From: Martyn White
Sent: 14 December 2018 16:31
To: Anita Gardner
Subject: LU/324/18/PL

LU/324/18/PL

The proposal is to demolish the existing building and construct a new fourteen bedroomed hotel and restaurant. It affects The Nelson Hotel which is located within a prominent location; at the southern end of Pier Road, and the junction with South terrace. It is visible from a number of locations.

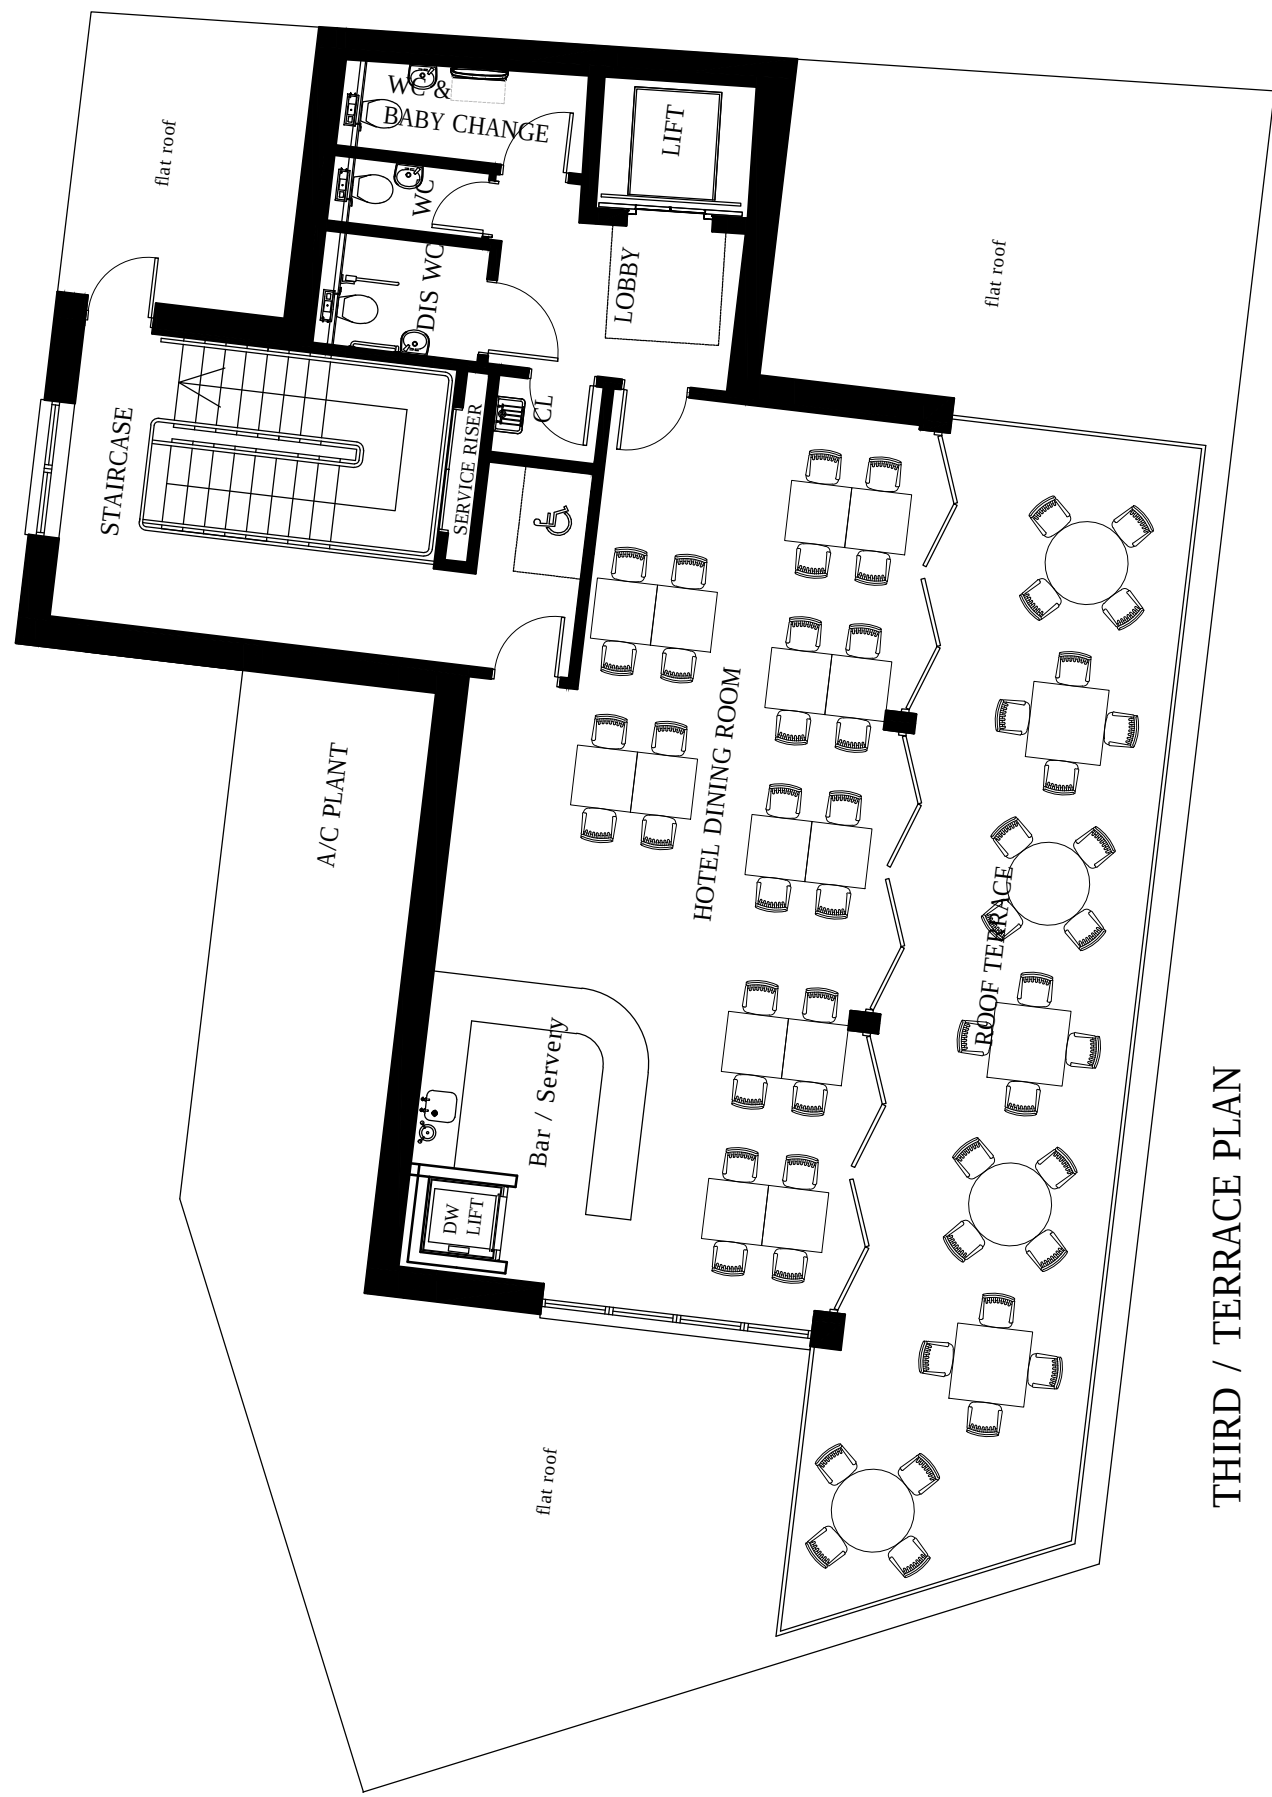
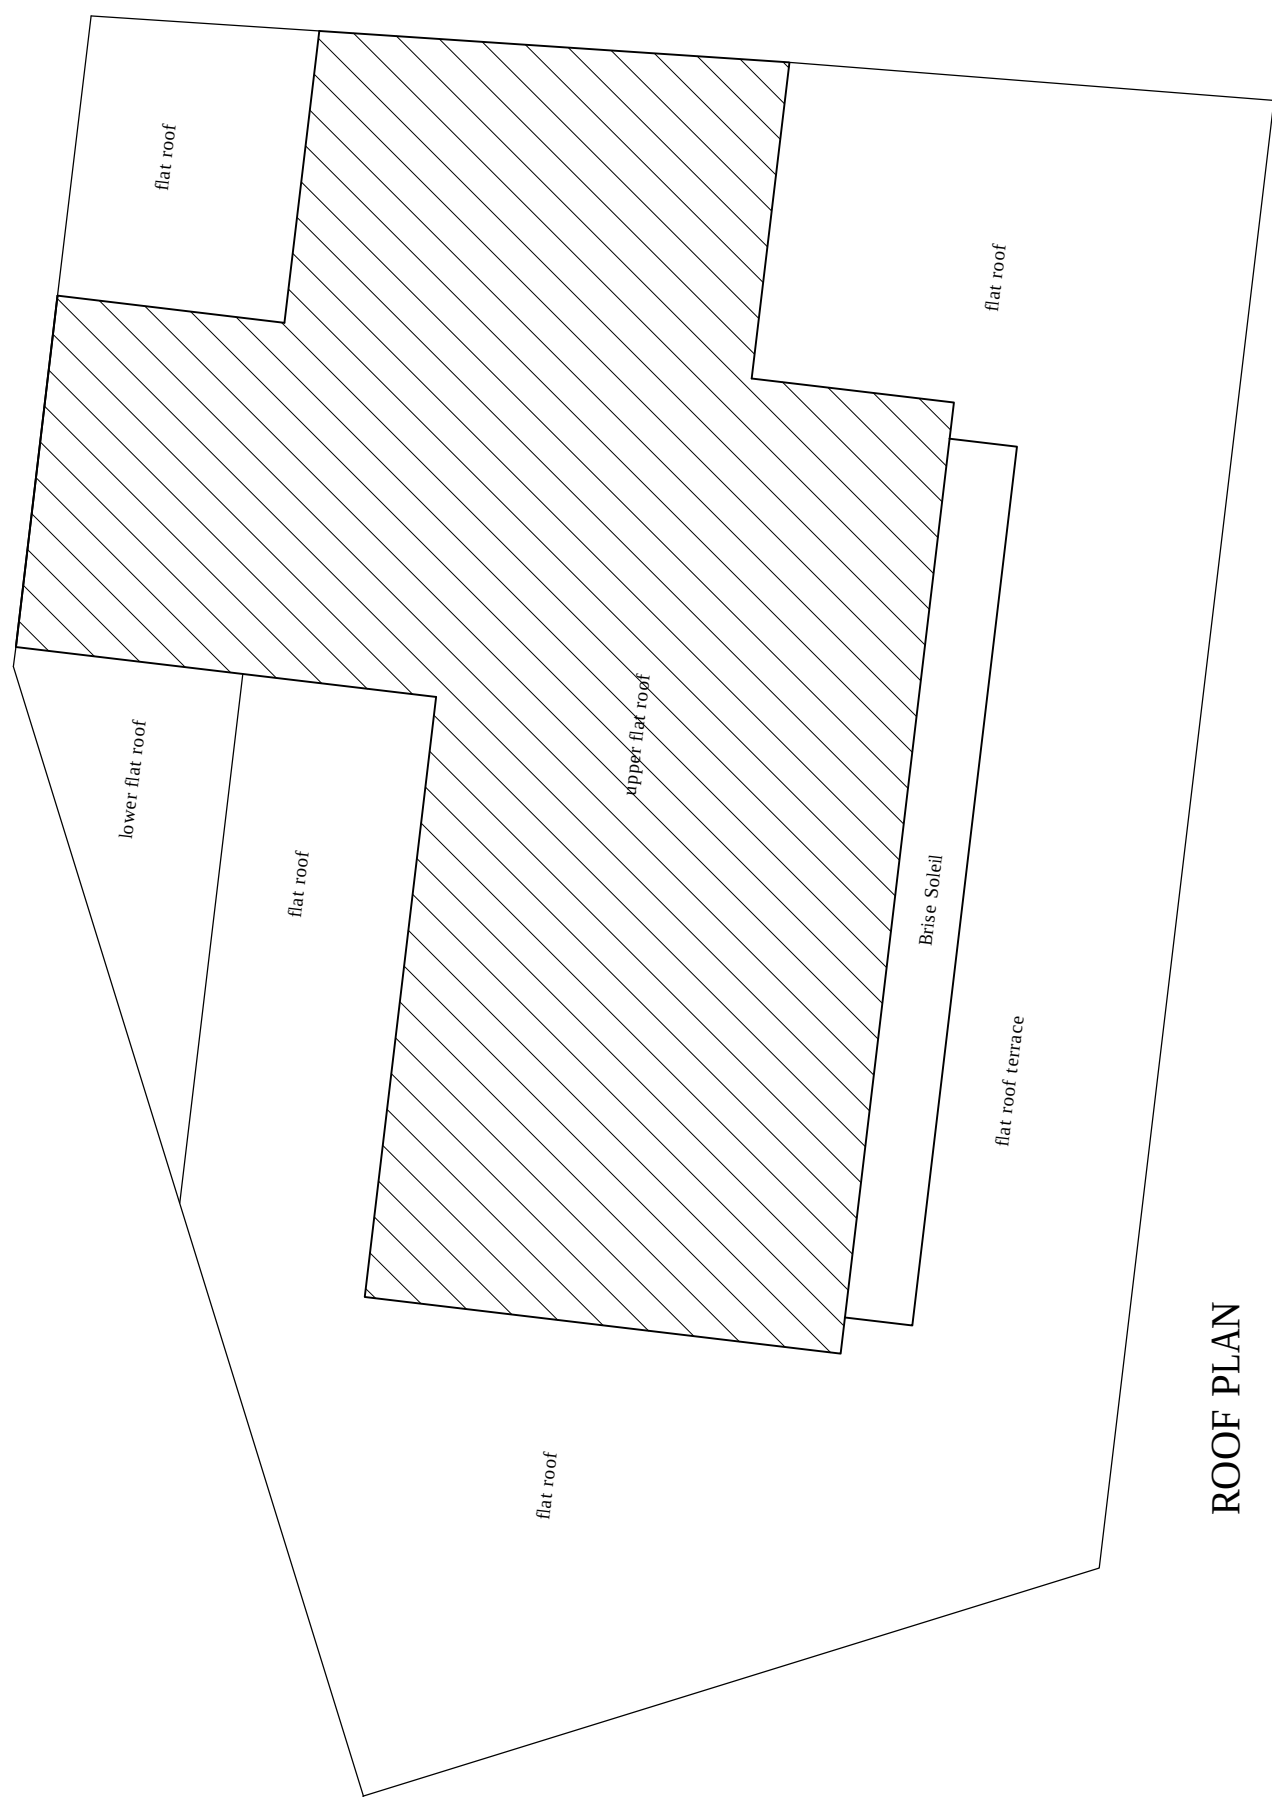
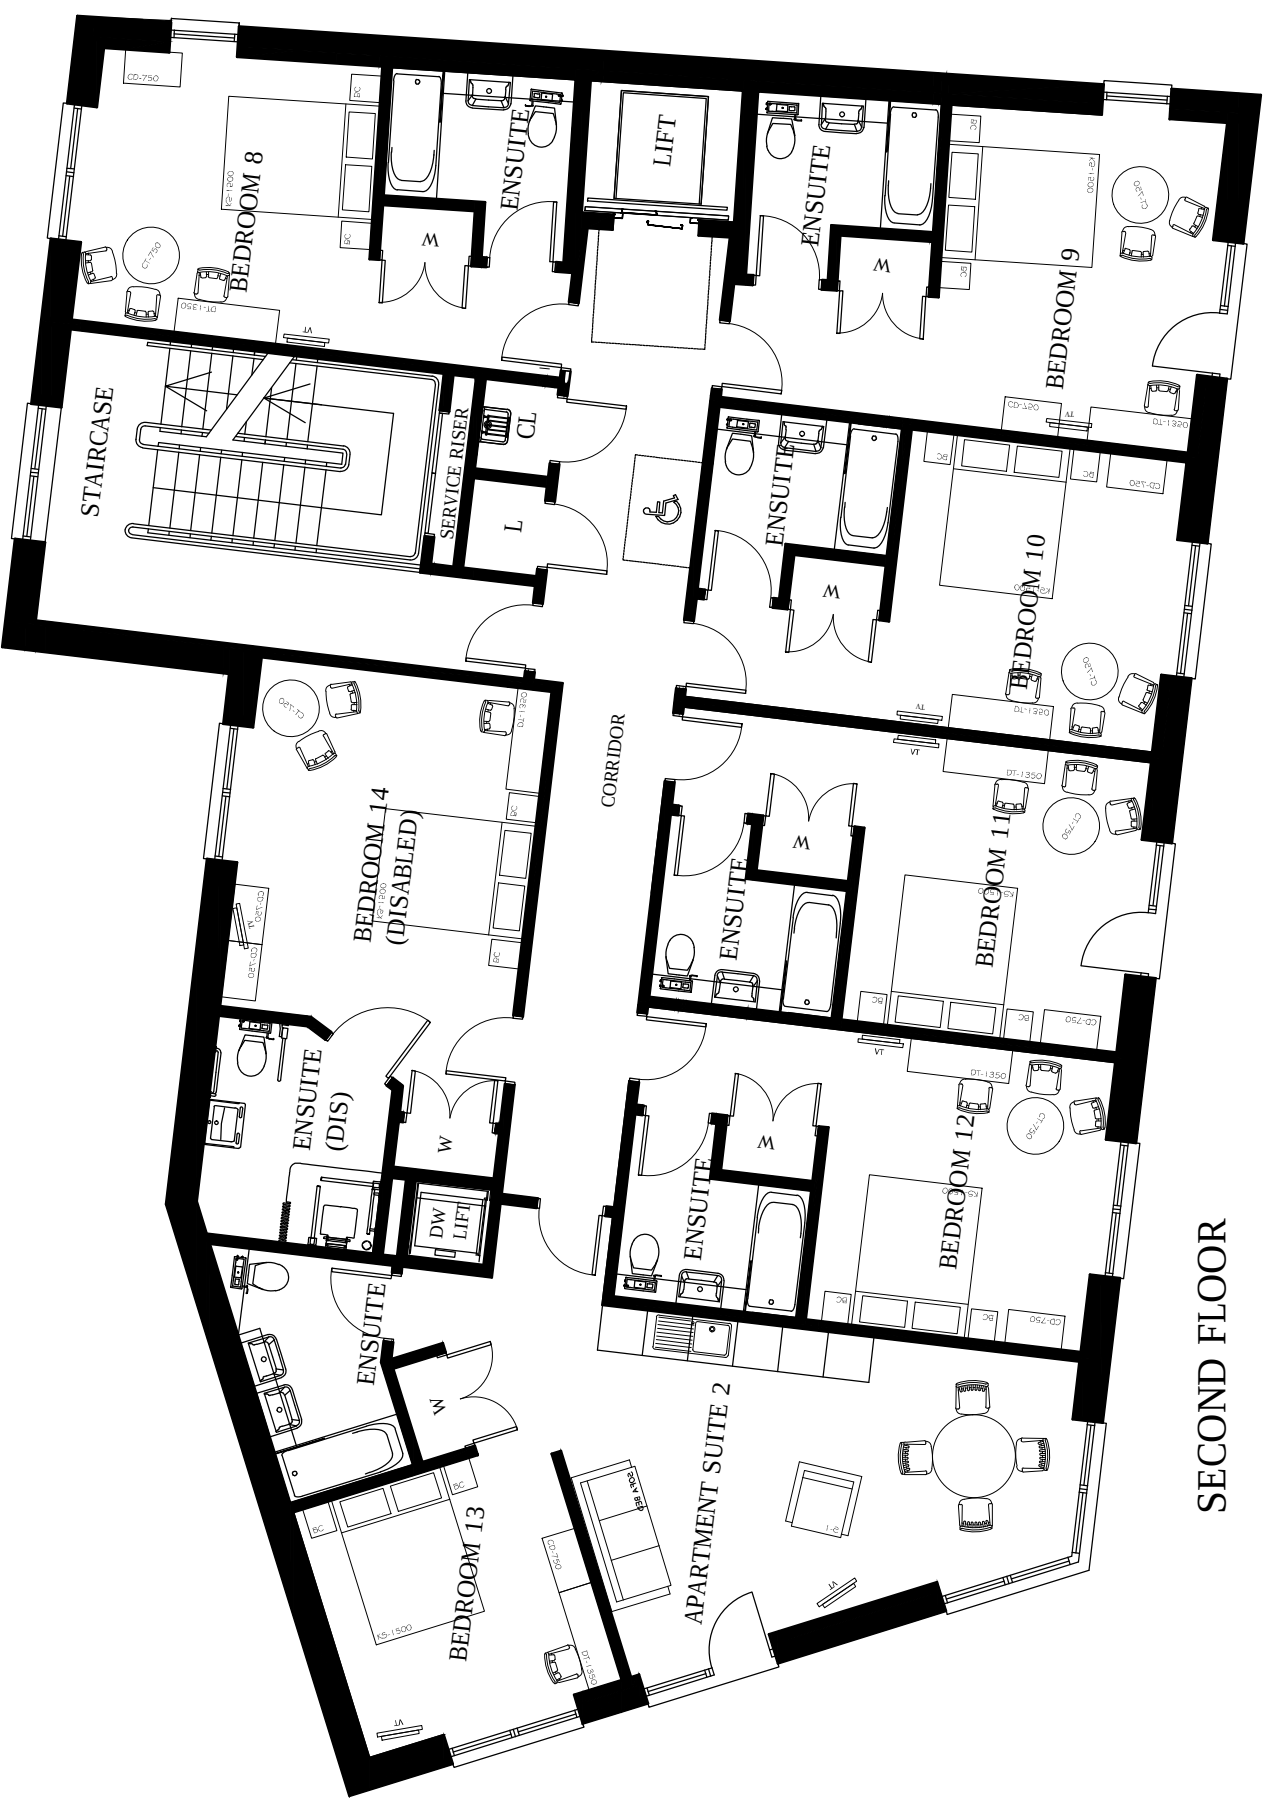
It is considered that the building now proposed is bulky, with a continuous elevation which wraps around the corner of the site. This is in contrast to the existing building which steps back from the pavement, and the neighbouring ones which contain a mixture of bay windows and other architectural details which provide some relief.

The elevation is composed of a mixture of glazing and coloured panelling, which is not found in the local area. It is therefore not clear how these panels reflect the established character of the area, nor do their colours. It is suggested that similar materials should be used to those traditionally used in the locality. This includes brick and render, both of which can be used in a modern context.

It is therefore considered that the proposal will detract from the established character of the area, as well as the setting of the adjoining attractive terrace (e.g. no's 92 -95 South Terrace which is included in the Council's List of Buildings of Character).
